Rear single storey extension
13 Gossamer Lane Aldwick

Thank you for your internet representation made on 16th April 2019 which has been recorded as '**an objection**' with the comments as follows:

DRAWING BLOCK PLAN DATE: MARCH 2019 DRAWN: T. Murray	SCALE 1/500
DRAWING: 19/15/5	REVISION:

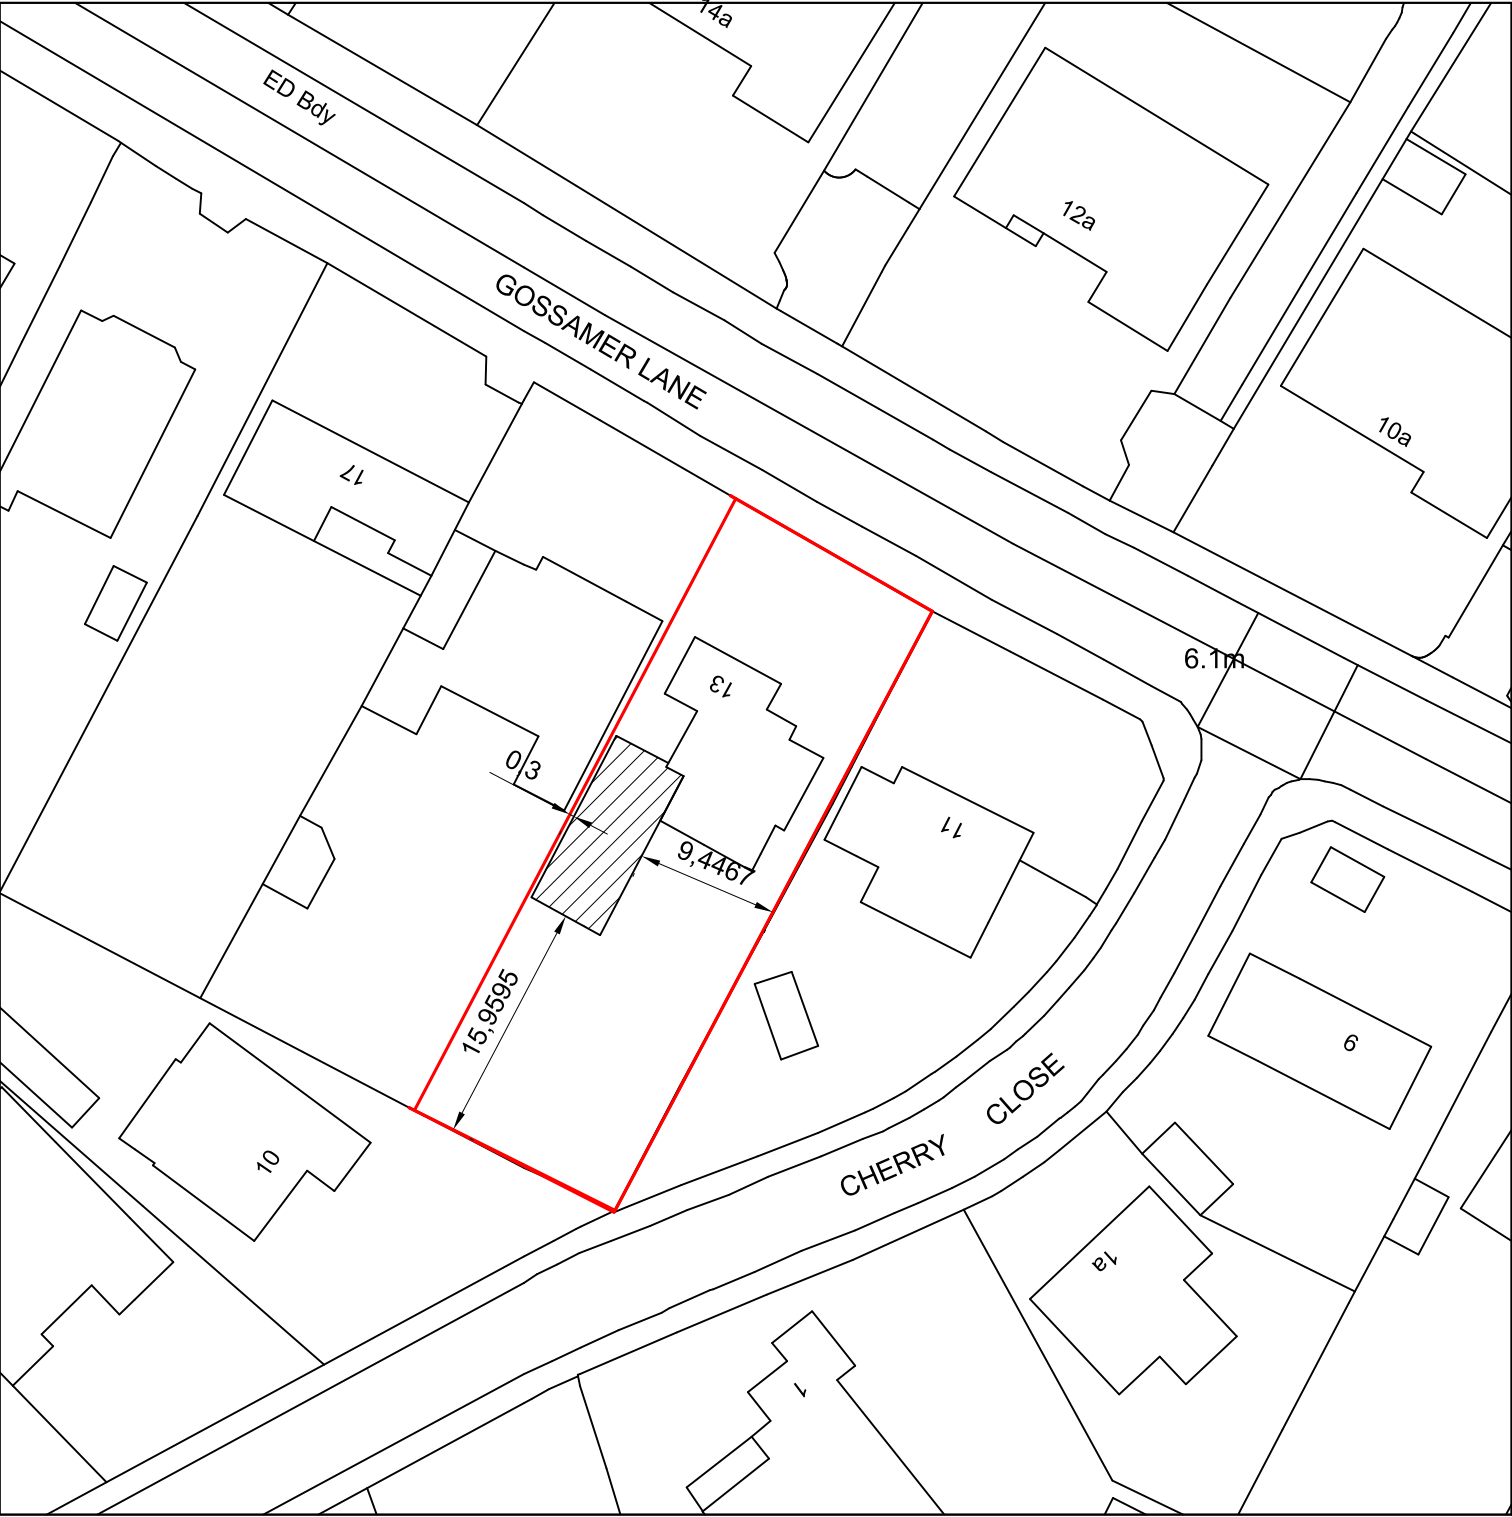
2) The block plan shows 3 cm clearance from my own ground floor extension and it is not clear what provision for guttering, down-pipes and run-off have been considered.

DRAWING PLANNING EXISTING DATE: MARCH 2019 DRAWN: T. Murray	SCALE 1/100 REVISION:

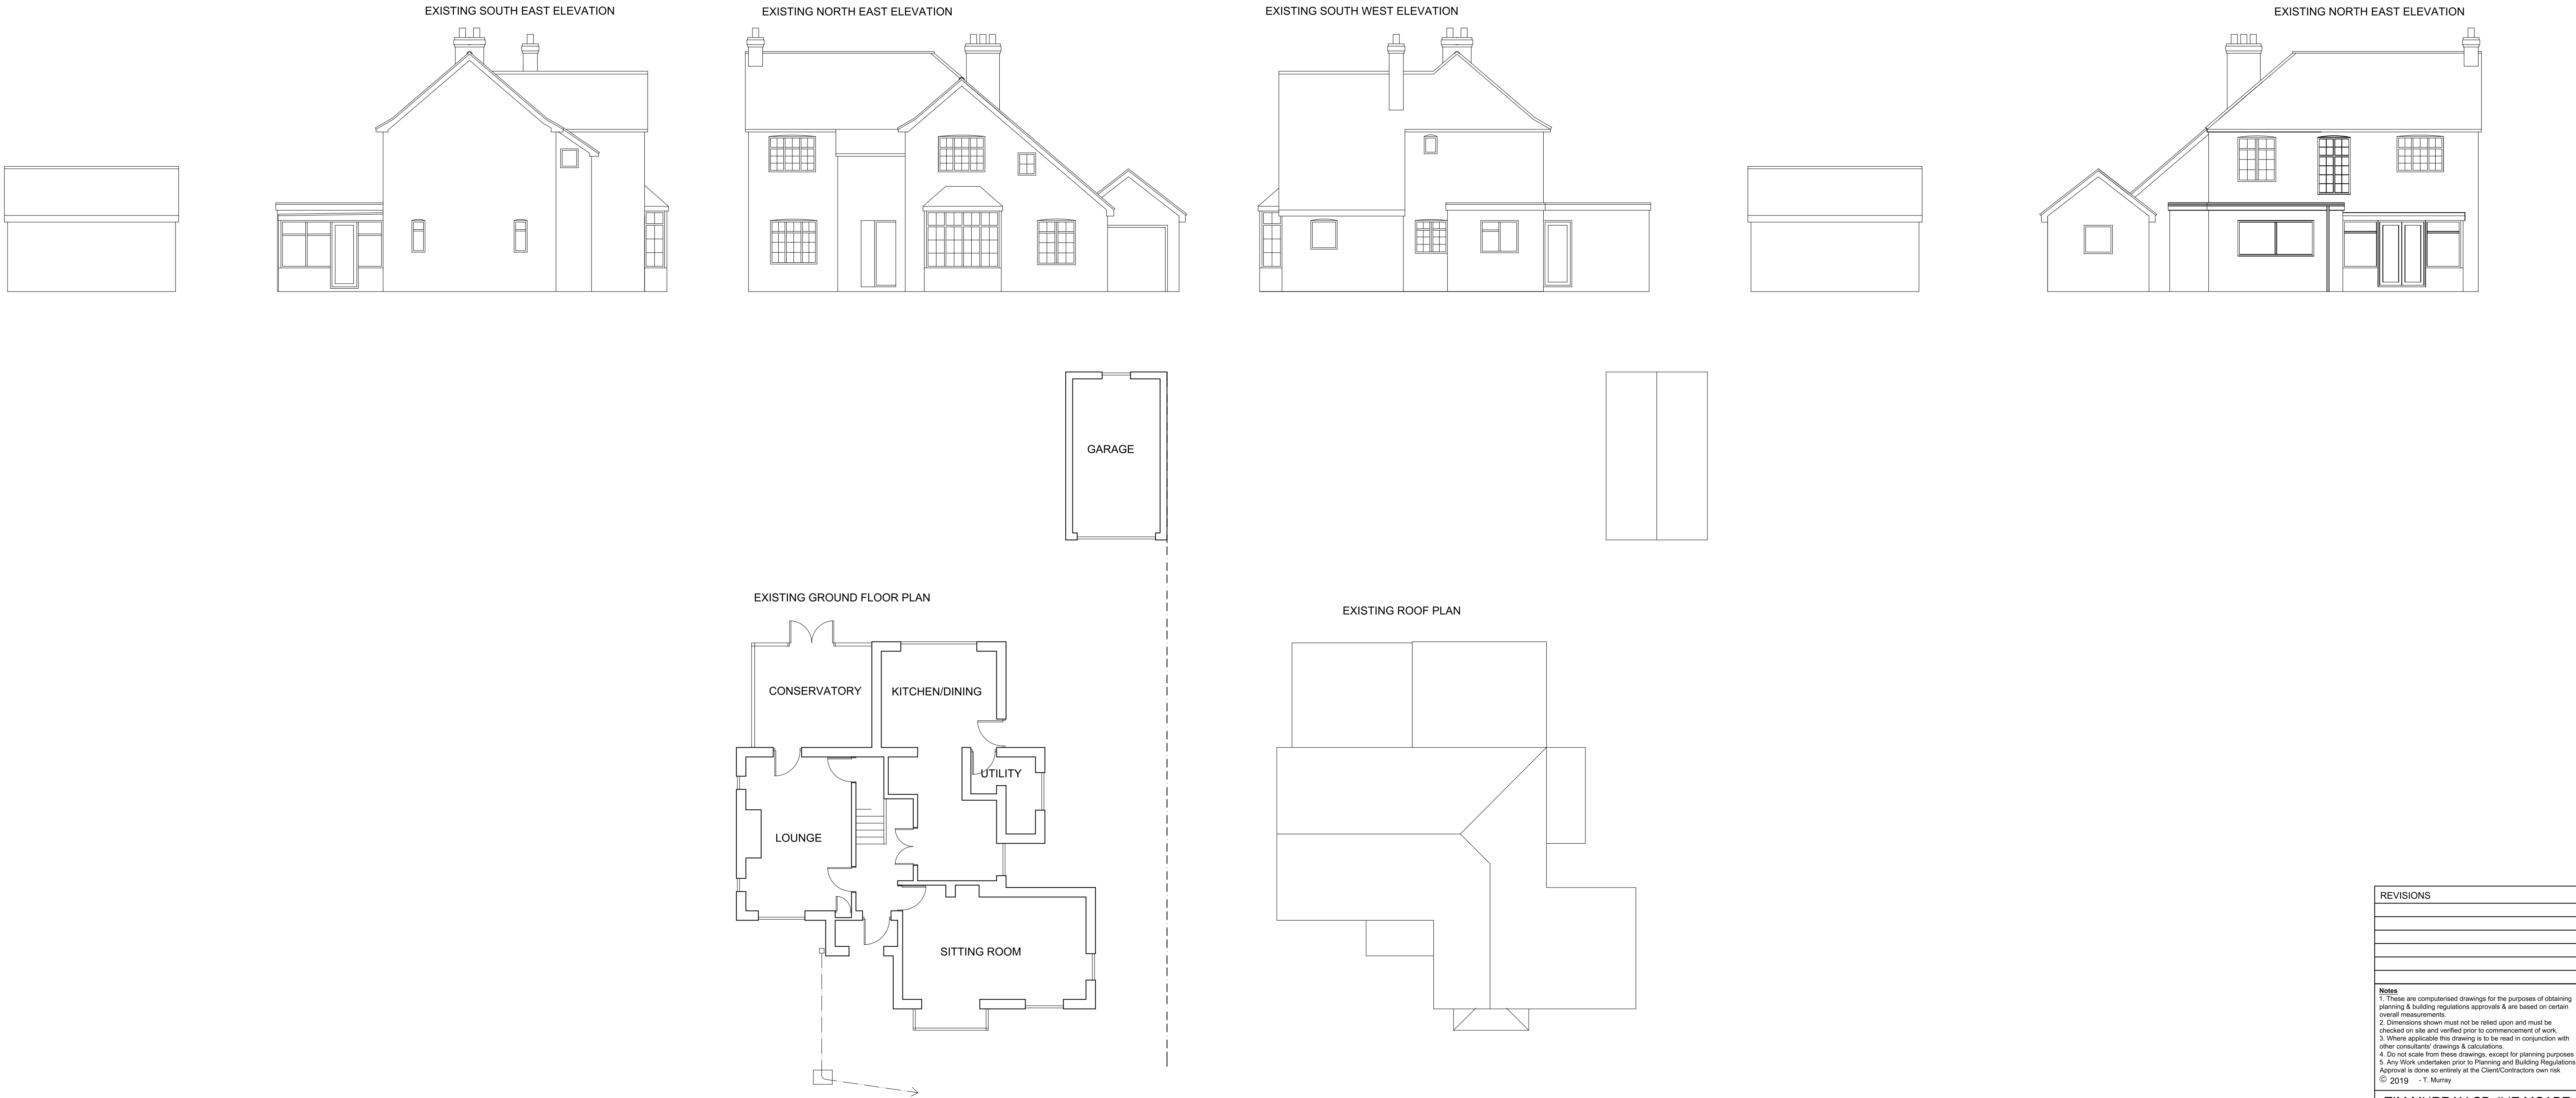
3) The apex of the proposed extension roof will be much higher than the existing garage roof causing lost of morning light from my garden.
